**DEVIATION REVIEW  
 AND DECISION FORM**

Subdivision or Project Name: Homestead at SR Filing No. 2

Section of ECM from Which Deviation is Sought: Appendix I Section 1.7.1.B  
 Specific Criteria from Which a Deviation is Sought: Providing Water Quality for Entire Development

HOMESTEAD AT STERLING RANCH FIL. NO. 2  
PROPOSED DRAINAGE MAP FOR DEVIATION REQUEST

HOMESTEAD AT STERLING RANCH FIL. NO. 2  
PROPOSED DRAINAGE MAP

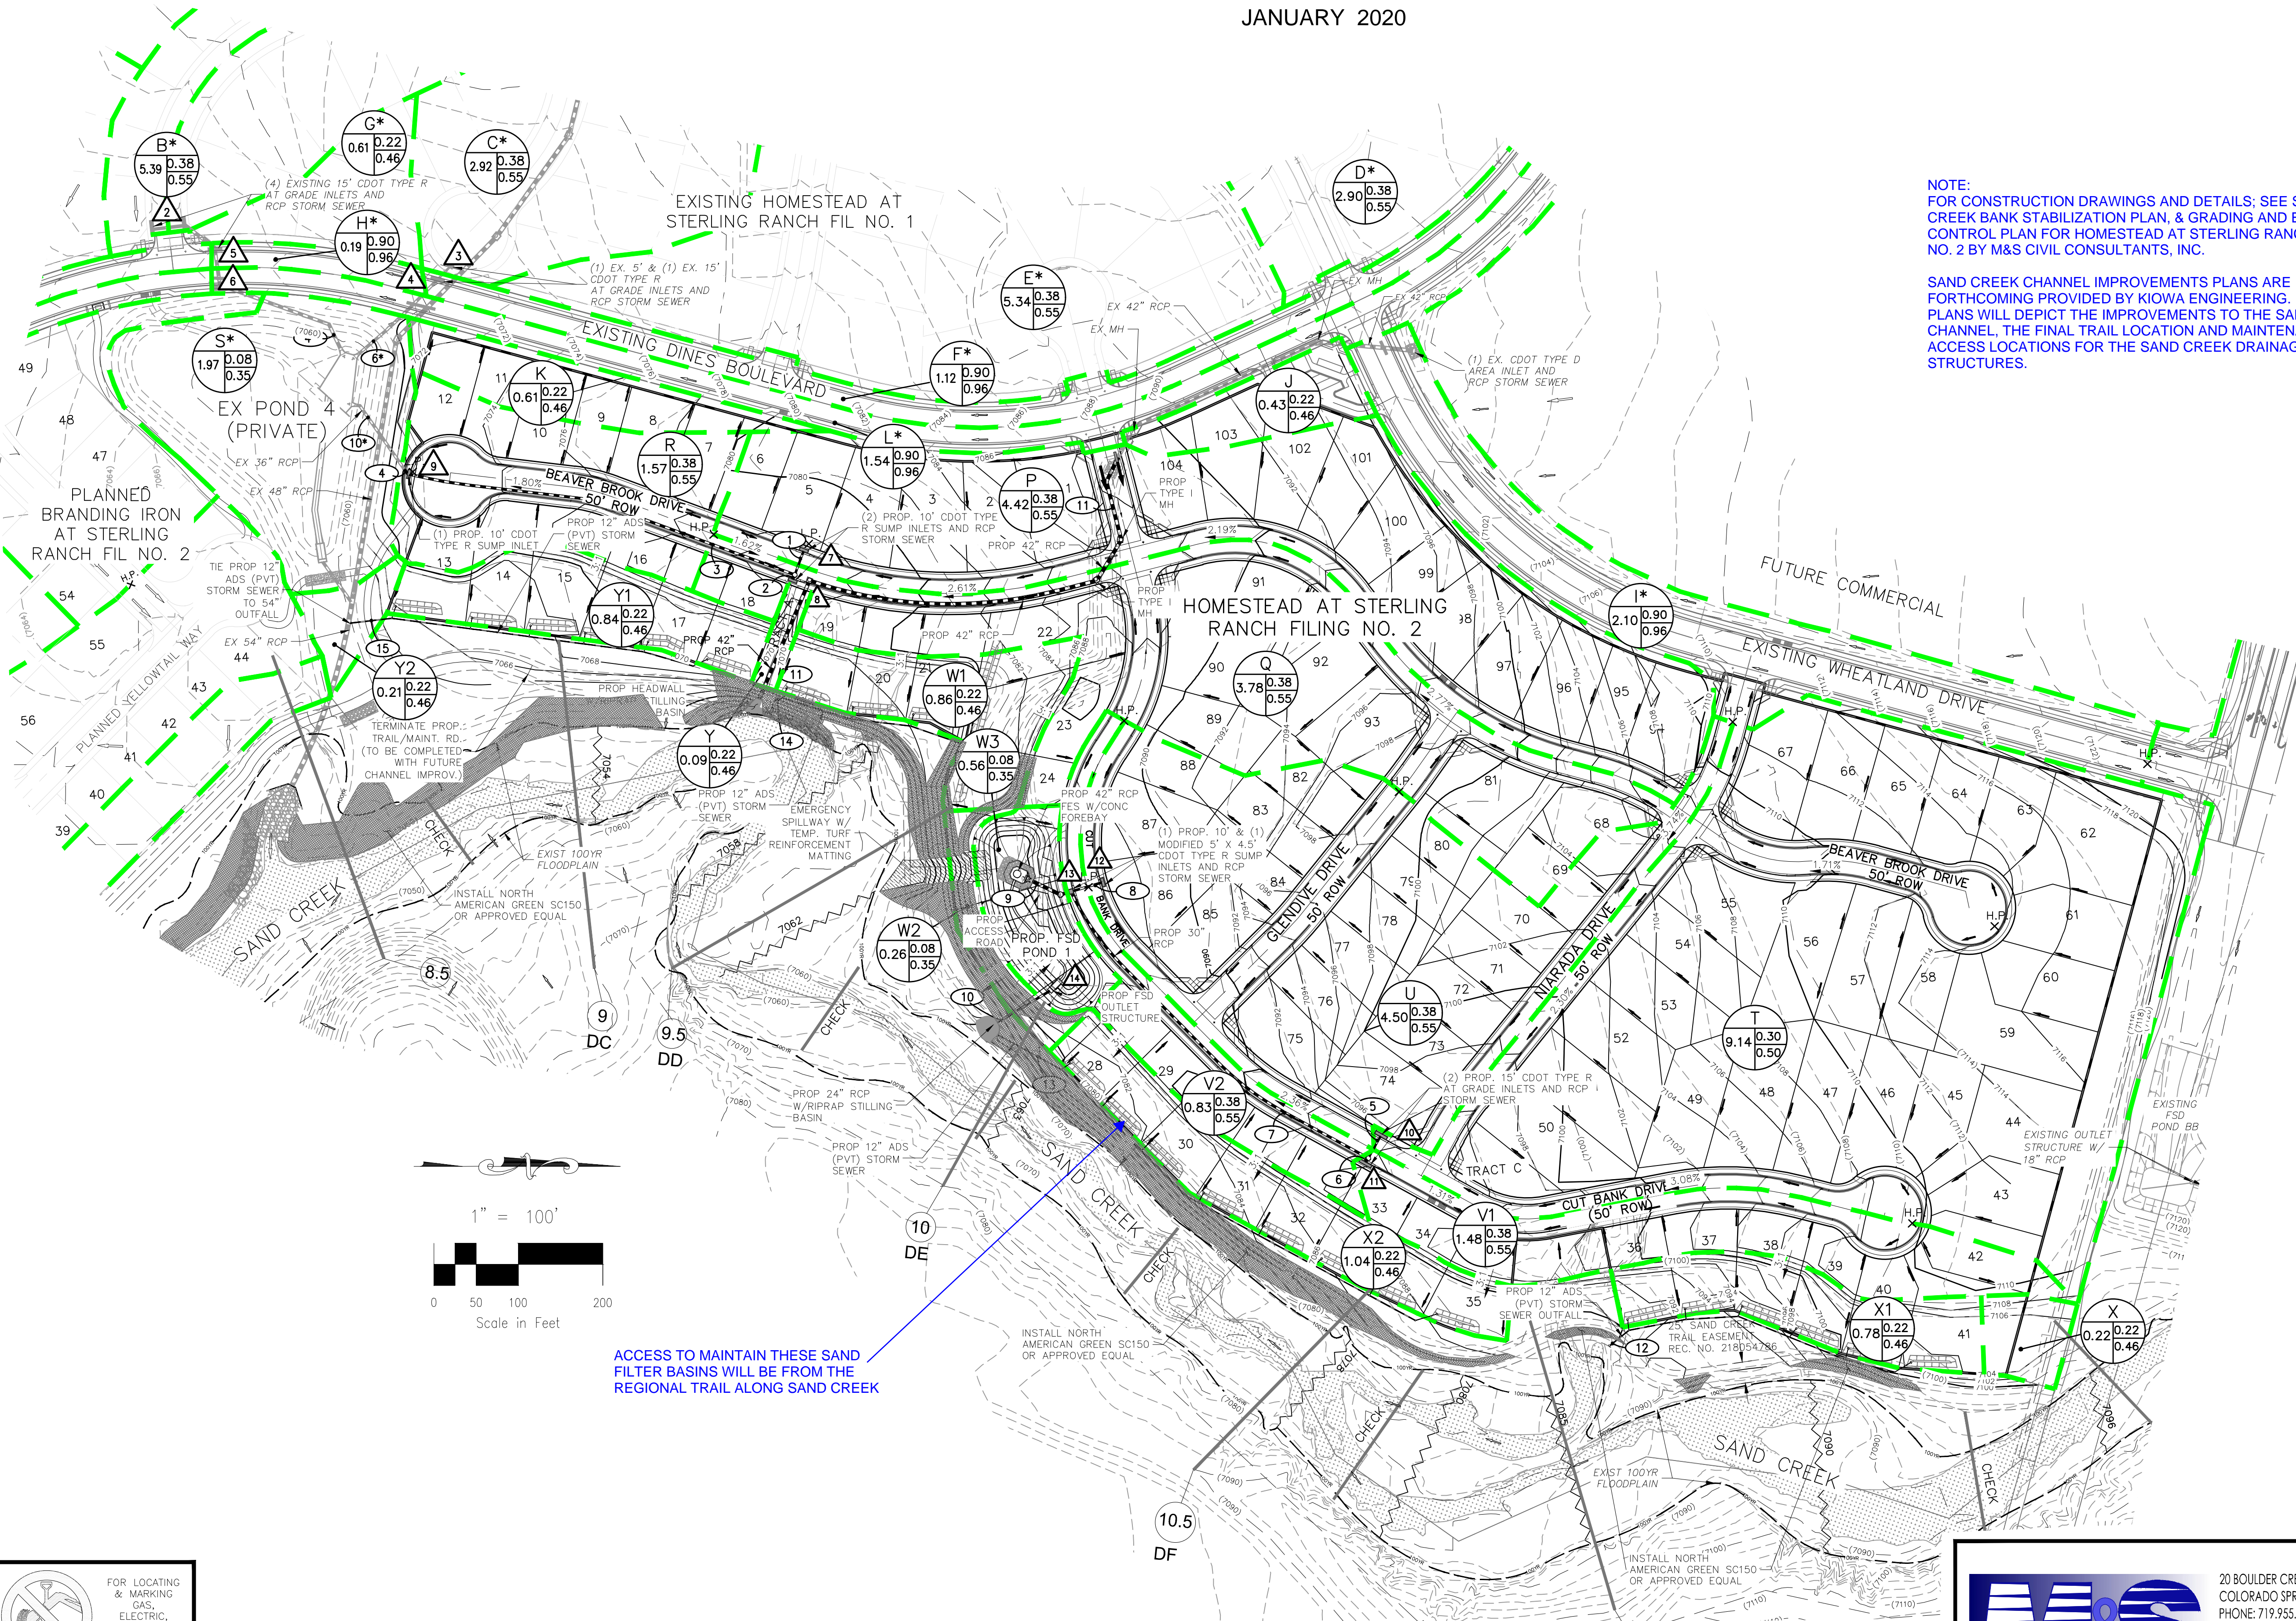
Full spectrum detention and SWQ capture volume is required for this area.  
 See comments on Drainage Report.
